Pearmtree Hill Solar Farm

Response to Rule 17 – Request for Further Information

Document Ref: EN010157/APP/8.27

December 2025

Figure 14.2: Transport Routing and the Existing Highway Network

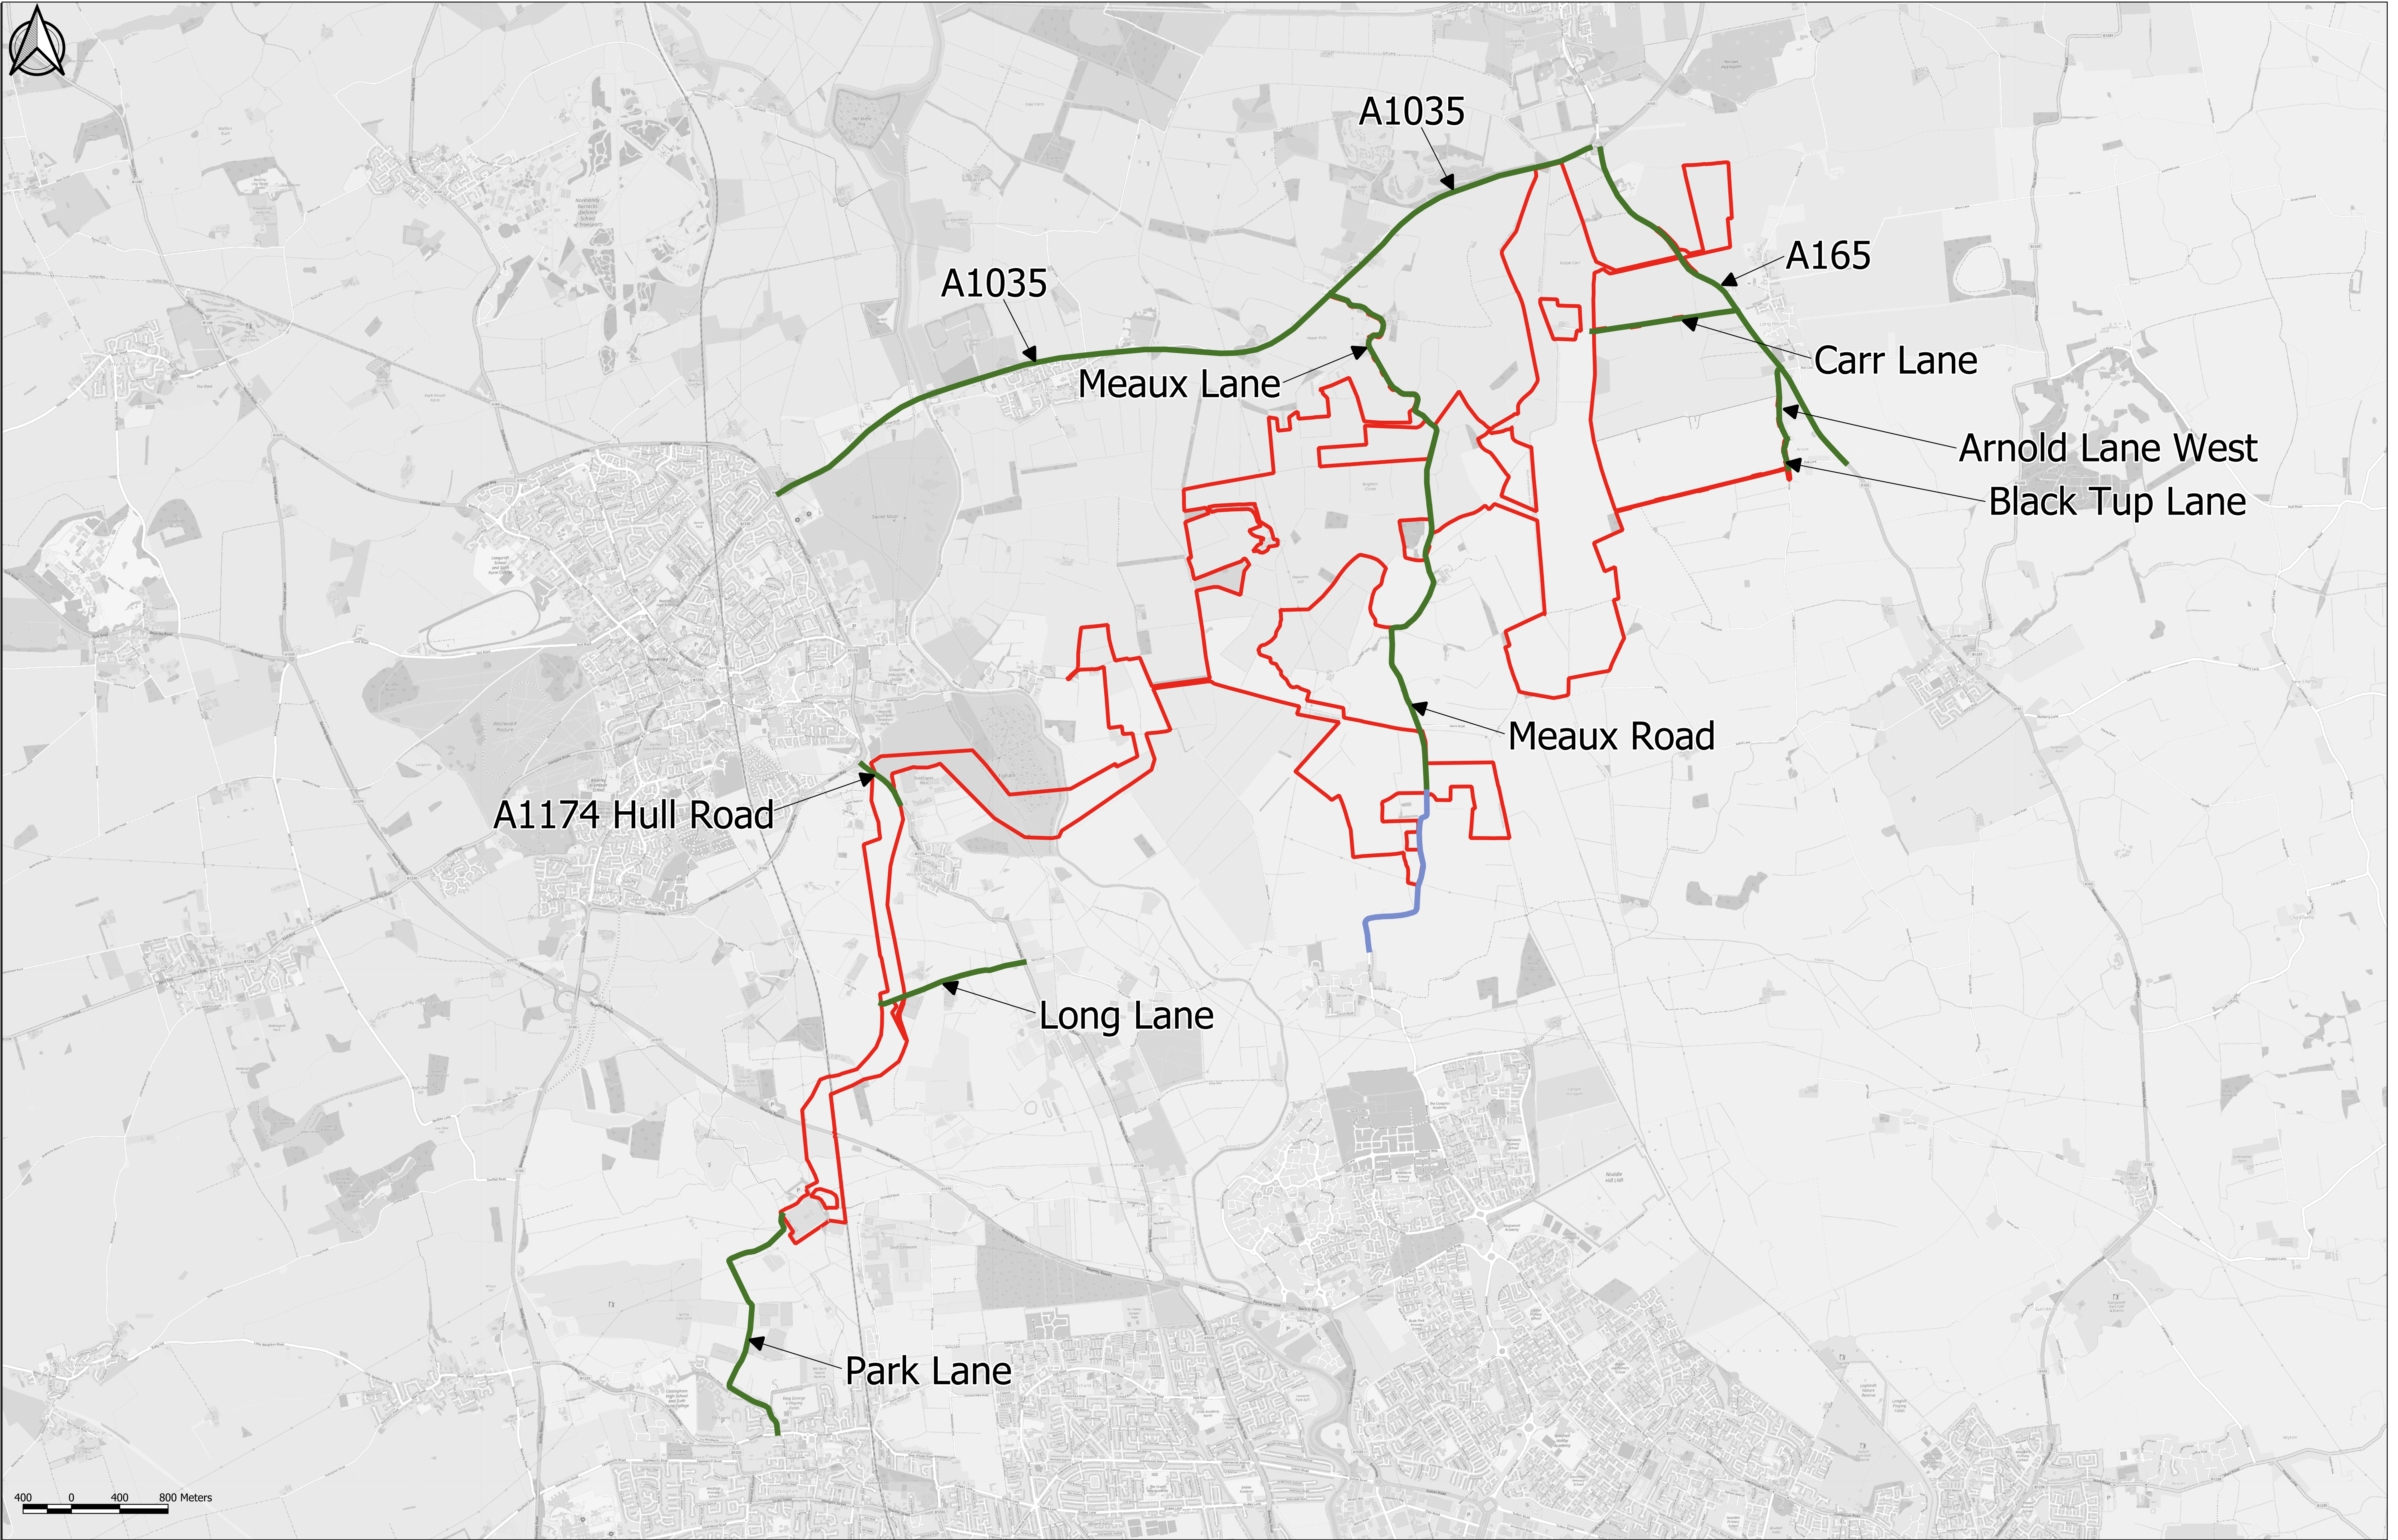
“The ExA notes the applicant’s response to ExQ3.5.1b) and c) [REP5-080]. However, some of the traffic figures (including 24, 27, 32, 34, 26, 40, 42, 44 and 48) of the Transport Assessment [REP4-025] state that “It is assumed that 50% of vehicles will travel to and from Hull Port via A1035 at Beverley and 50% via the A165.”. The ExA is therefore unclear how the applicant concludes that “[...] traffic routing to and from the Site along sections of route A63 will not pass through Hull AQMA 1.”. The ExA therefore requests:

a) Further information around anticipated annual average daily traffic (AADT) levels on the A63 through Hull’s air quality management area (AQMA) and, if this is likely to exceed the relevant criteria, further justification for a lack of an air quality assessment in this regard; and

1.1.3 Whilst the numbers stated are correct, the text on the traffic figures was a wording inconsistency that could be interpreted as implying all HGV and LGV construction trips travel to and from the Port of Hull, which would not be the case. The correct wording for the purposes of all the assessments in **ES Volume 4, Appendix 14.1: Transport Assessment [REP4-026]** and **ES Volume 2, Chapter 14: Transport and Access [REP5-018]** is set out in Table 14-4 of **ES Volume 2, Chapter 14: Transport and Access [REP5-018]** in relation to the construction assumption for ‘Distribution of Delivery LGVs and HGVs’ and reads as follows:

“For the purposes of this assessment, it has been assumed that HGVs and LGVs will access the Site either from Strategic Road Network at Hull Docks or the A1(M)/M62. For local road assessment within the study area, it has been assumed that 50% of delivery vehicles will access the Site via the A165 and 50% will access via the A1035 at Beverley.”

Image 1: Snip of ES Volume 3, Figure 14.2 Transport Routing and the Existing Highway Network [REP2-121]

- 1.1.5 Based on the above assumption and the transport routing shown in Image 1, it has been assumed that construction LGVs and HGVs will either access the site via the A165 from the Port of Hull *or* along the A164 and A1035 from the wider Strategic Road Network (SRN).
- 1.1.6 It is not anticipated that construction LGVs and HGVs to/from the Port would need to pass along the A63 through the Air Quality Management Area (AQMA) declared in the city of Hull (see Image 2), as the most direct route to/from the Site is along the A165. Similarly, it is not anticipated that construction LGVs and HGVs to/from the wider SRN and motorway network (M62 and A1(M)) would need to pass along the A63 through the AQMA, as the most direct route is along the A164.
